**Re: Mercado El Milagro, Building G at 10,000 Central Ave SW  
Erosion and Sediment Control Plan  
Engineer's Stamp Date – 5/23/2023 (L09E042B)**

Based upon the information provided in your submittal received 5/30/2023, the ESC Plan cannot be approved for Building Permit until after the following comments are addressed.

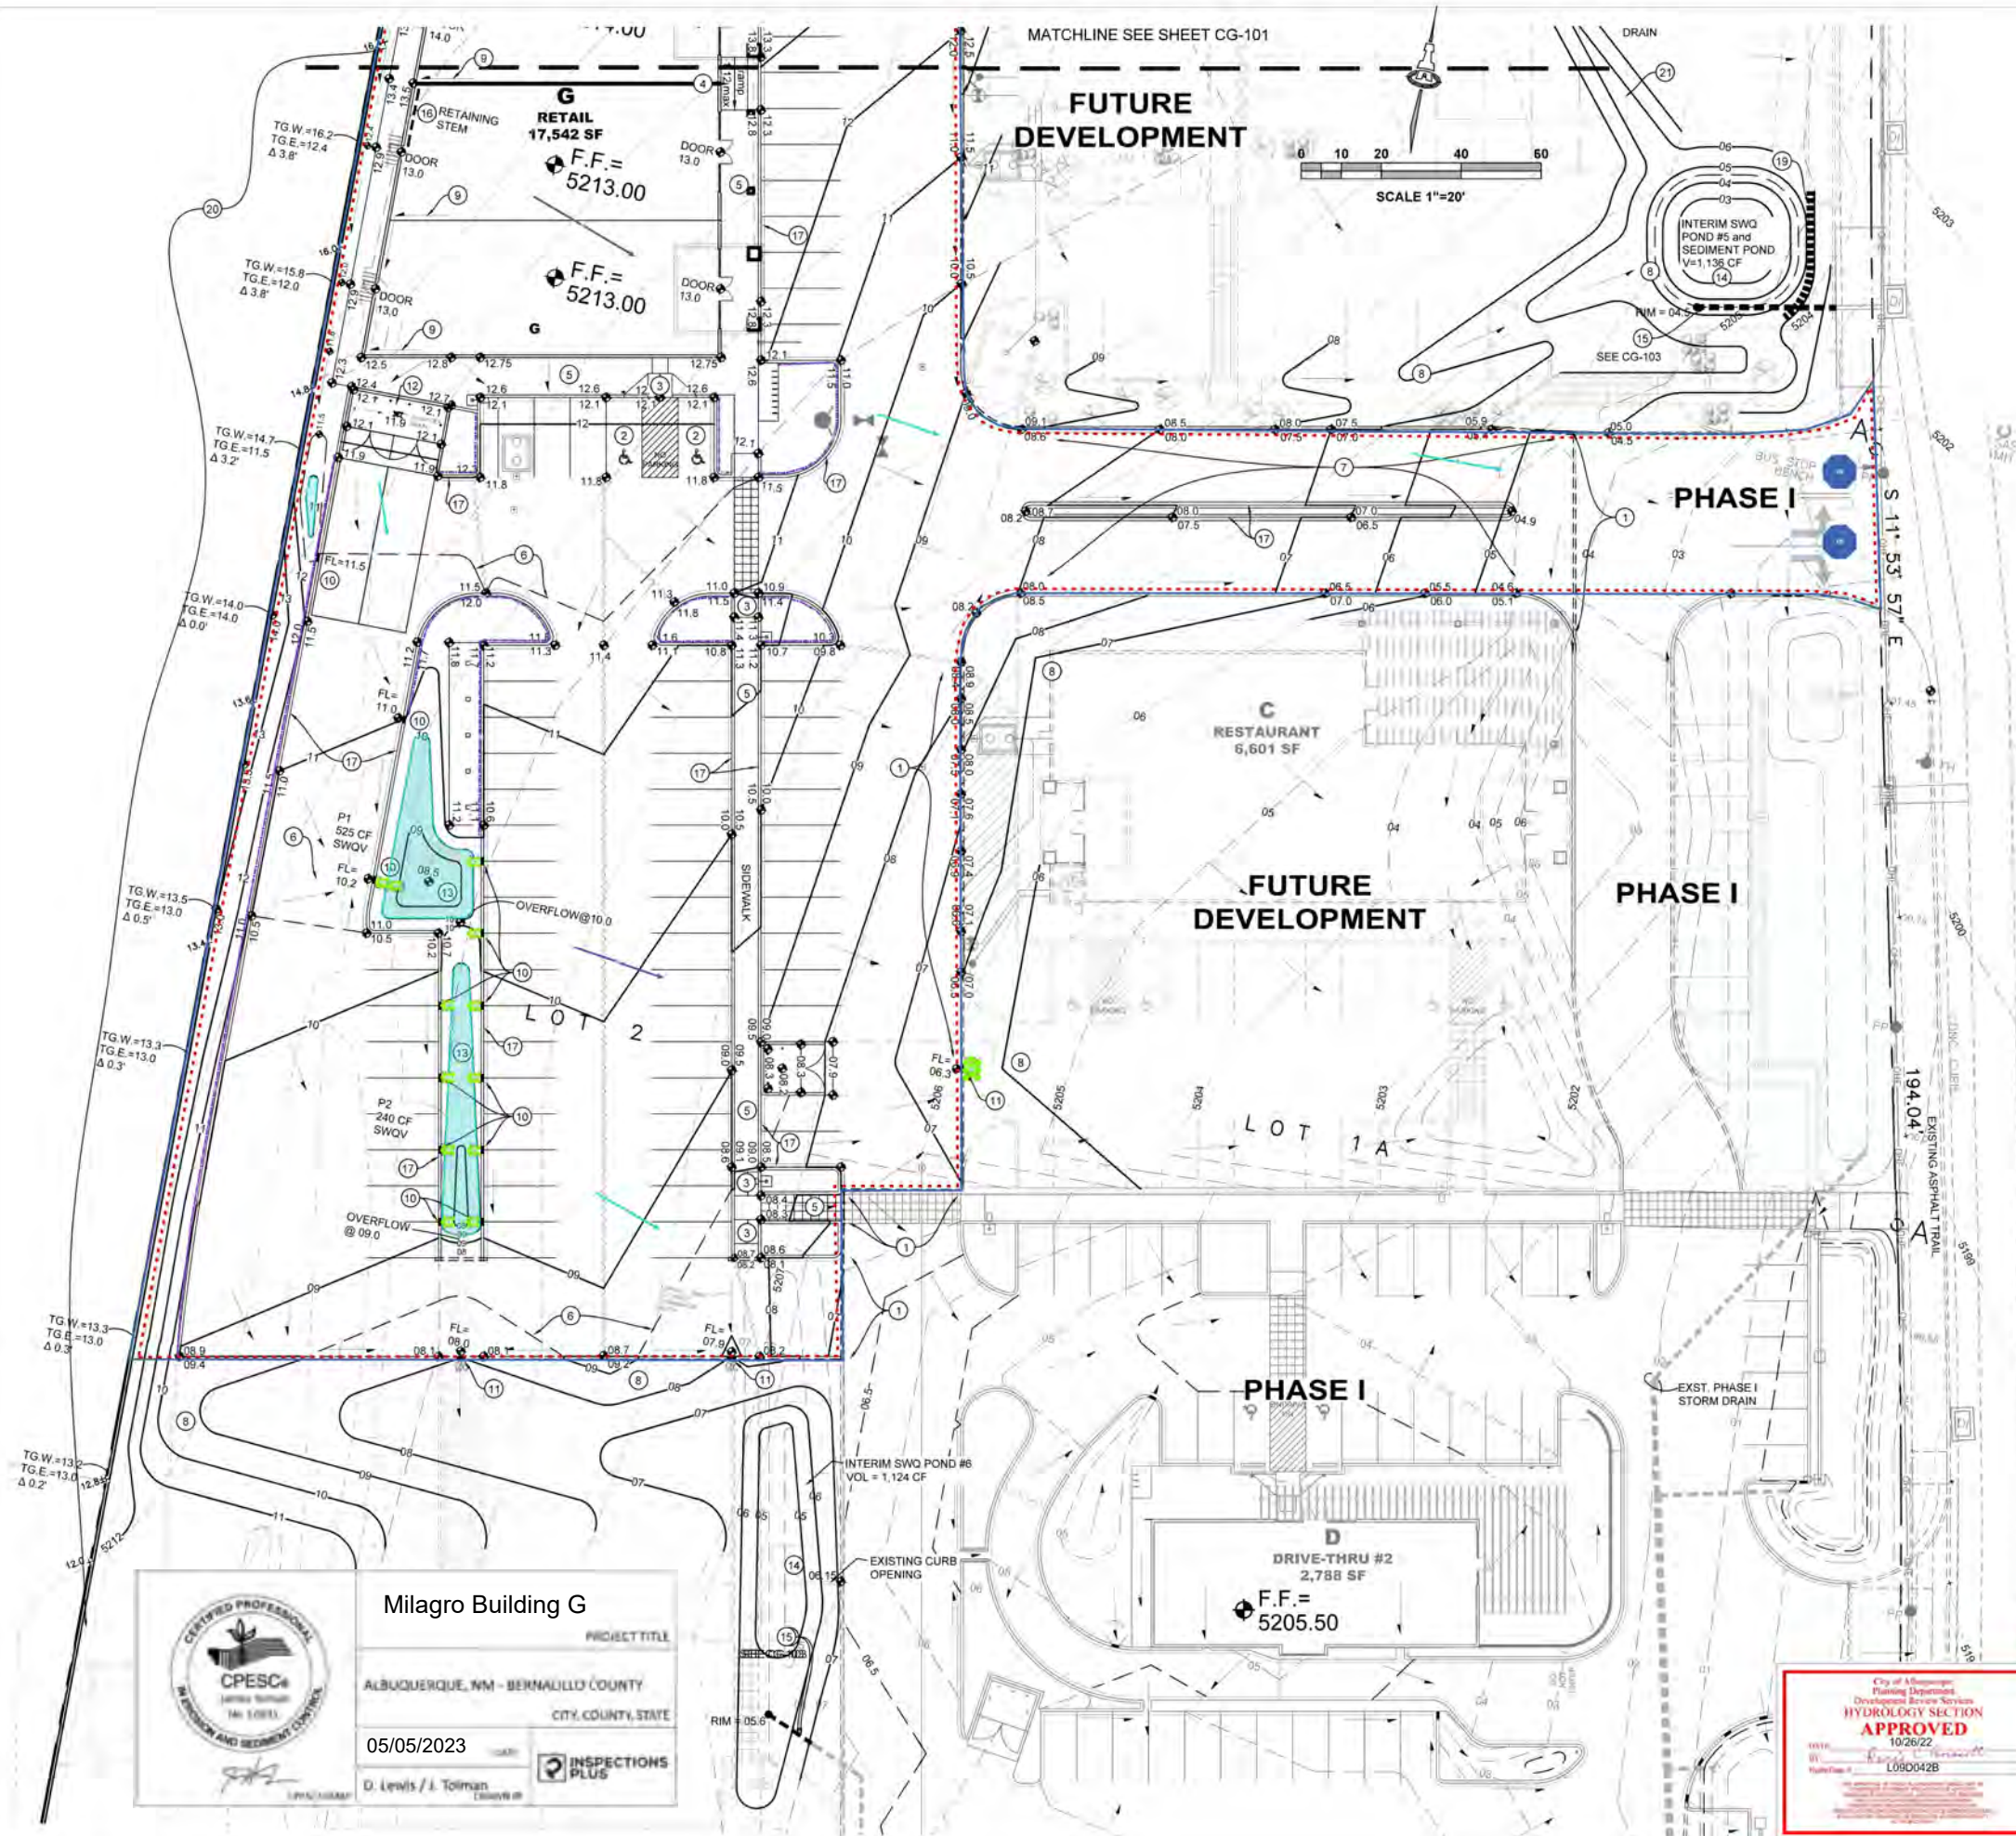
1. You must move the "Limits of Disturbance" and "Silt-fence" to include the required temporary tie-in slopes, swales, and ponds (Interim SWQ Ponds #5 and #6) that Hydrology approved for Building Permit for Building G.
2. You must include stabilization specifications for the temporary tie-in slopes, swales, and ponds.
3. If the Limits of Disturbance and Silt fence are shown on the Conceptual G&D Plan that says "Not for Construction", then they should be in the same location as shown on the other sheets. Future phases have not been approved by Hydrology for construction at this time. This ESC Plan and NOI will only be approved for land disturbing activities that have been approved by Hydrology.
4. You must provide a professional's stamp, date, and signature on all sheets. The date must be the same on all sheets, and you must update the date each time the ESC Plan is changed.
